**BP 2016-1405**

I am reviewing your project and have some questions about the proposed plans;

FIRST FLOOR PLAN

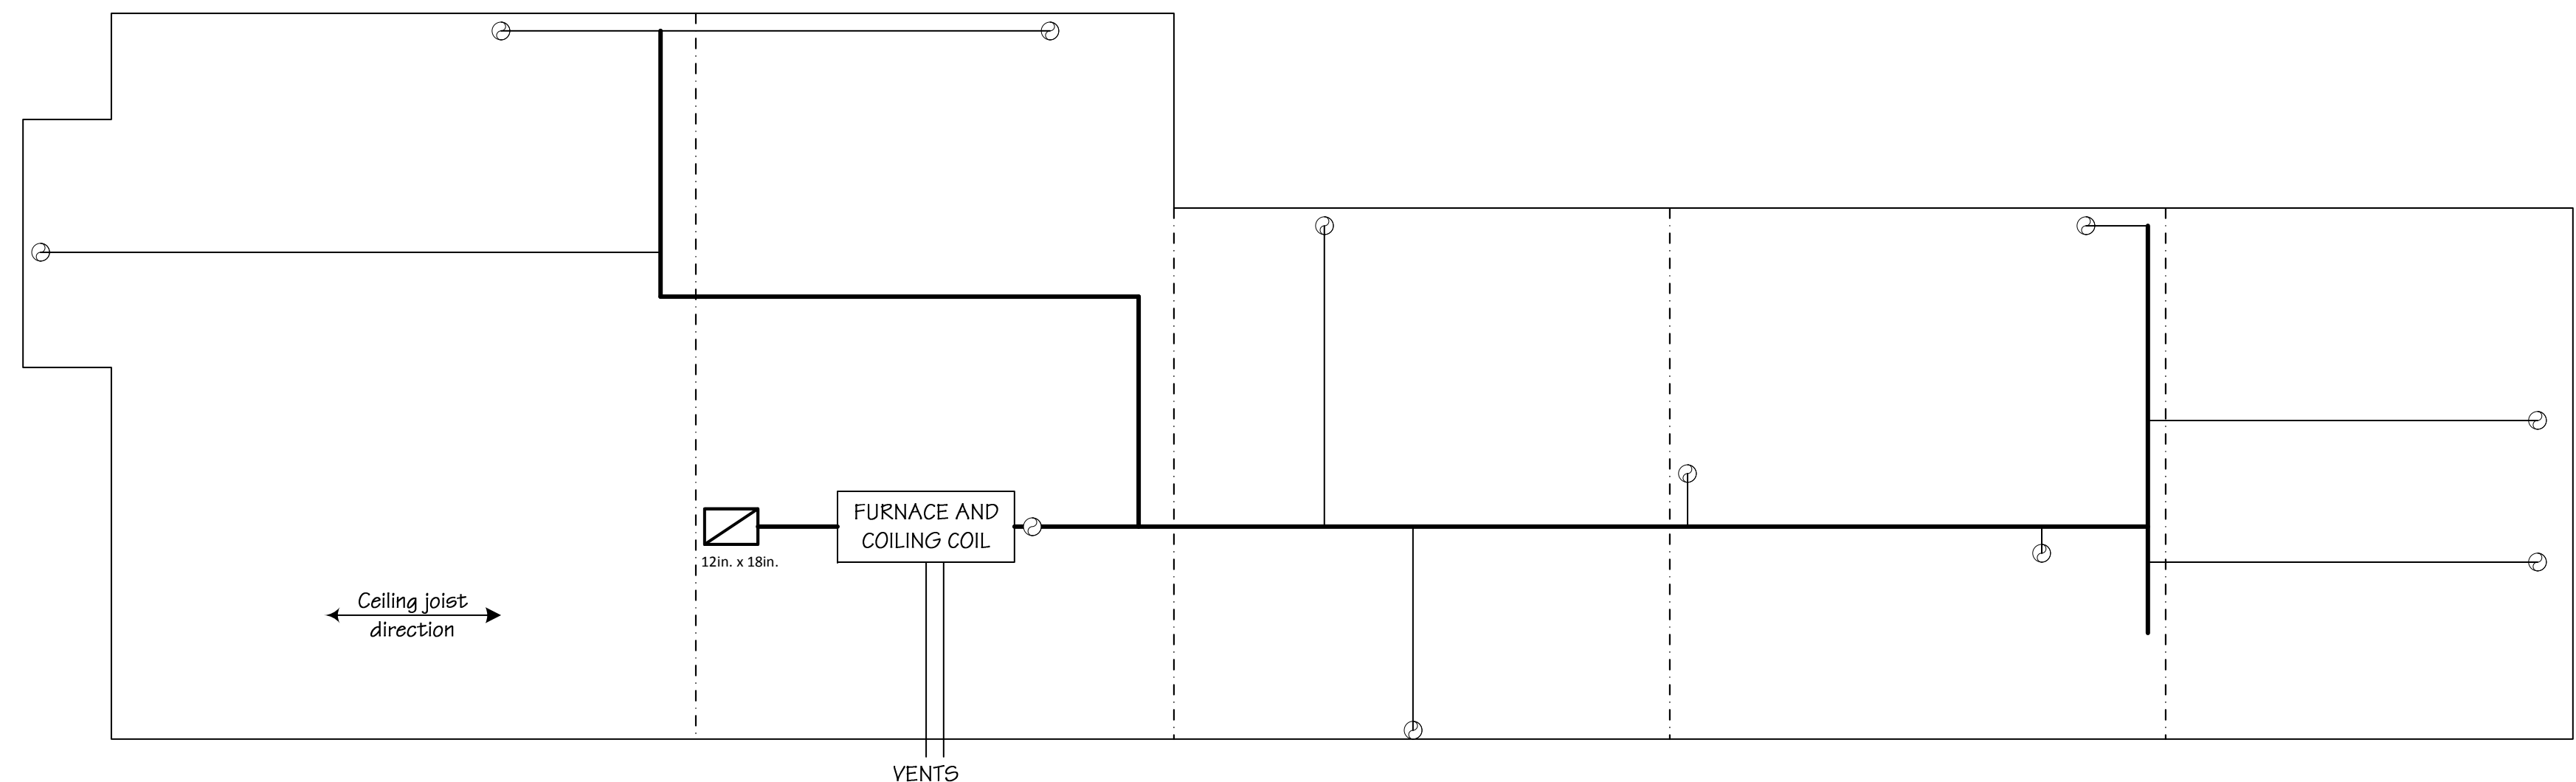
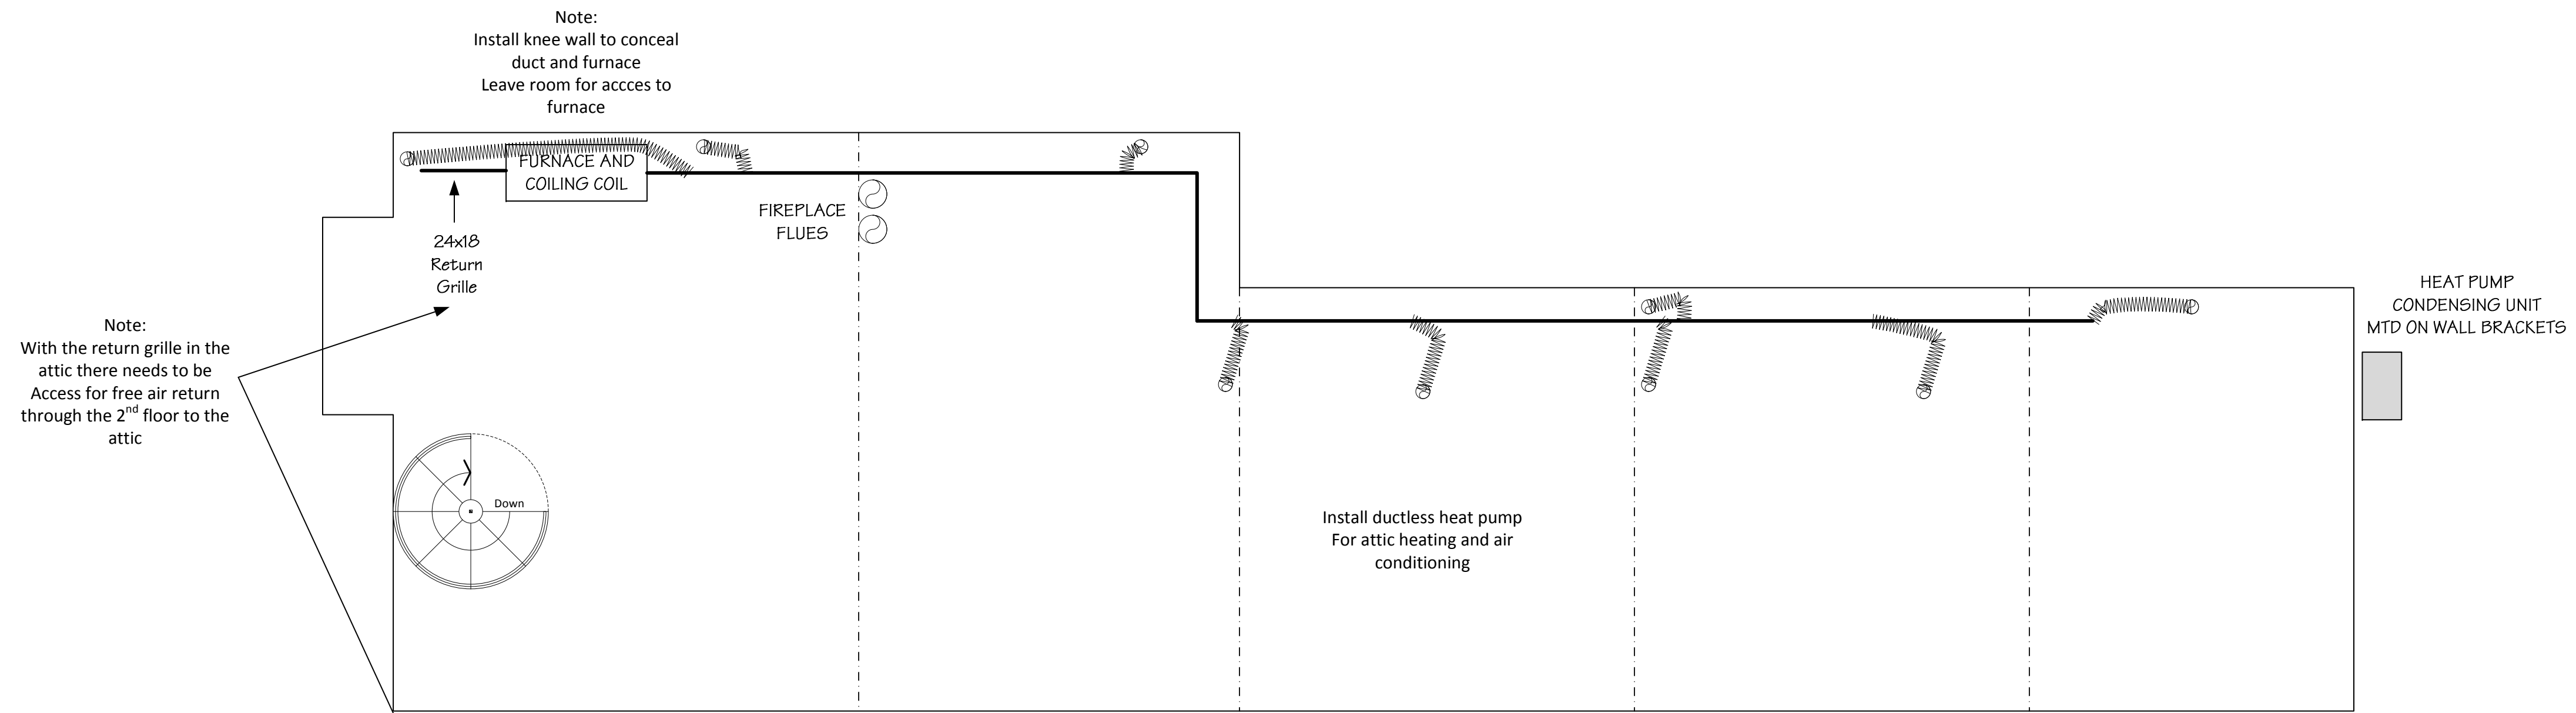
- \* Does the proposed floor plan for 1st and 2nd floors represent both floors (mirror image)? Please provide details for both floors.
- \* It appears the rear stairs will be removed. How will this be framed in and separated (fire rated)?
- \* What does the plan with the soffit represent? How will this be enclosed?
- \* The proposal includes a rear deck for the first floor, this is not on the submitted plans, please provide details on the plans.

- Yes, the first and second floor are going to be exactly the same, and same size. However, the second floor does have a third floor attic space that is useable floor space.
- The rear stairs were removed, as they were unstable, narrow, and barely straight. The new stairs to the second floor, will not be internal like the old ones, they are pressure treated stairs to the second floor deck. The deck is almost brand new, and very well done, overkill in some instances. The new stairs and deck have 6x6 posts, and completely enclosed to code.
- The soffit was for the old HVAC plan, as I was going to run duct work for AC. We are no longer doing that, only

going to add a heat pump in the future, but not now. Sorry for the old drawing.

- There is no rear deck, it is just a paver patio in the small existing grass area, outside of the master bedroom on the first floor.

ATTIC FLOOR PLAN

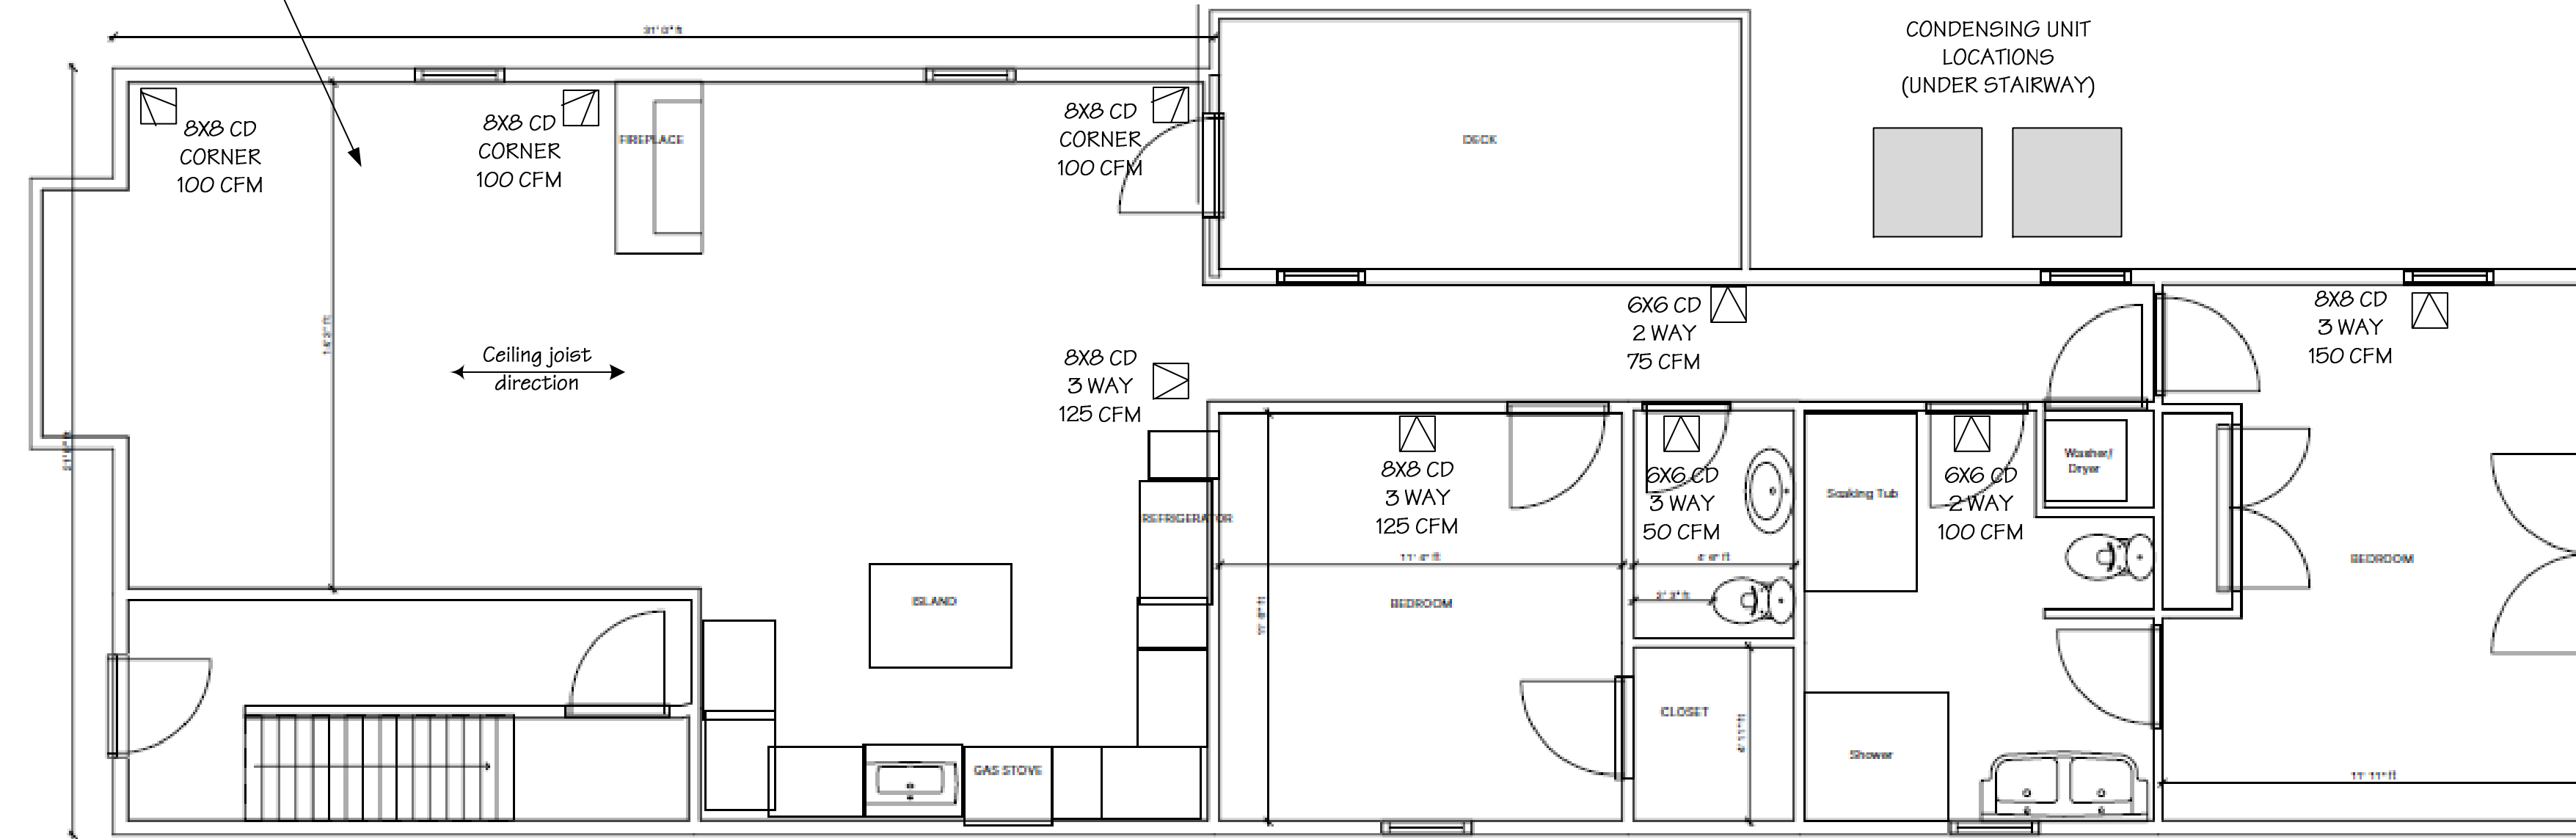
Please submit a plan for the habitable space in the attic as well as the egress for the second floor onto the deck, with the stairs included.

I'm waiting from my builder, to give me his specs on the stairs that will lead up to the second floor deck. However, the layout of the entire condominium facility, are attached. The third floor space is going to simply be a bonus room, left wide open, as it is currently. Wasn't sure if you had seen these yet or not, but might help.
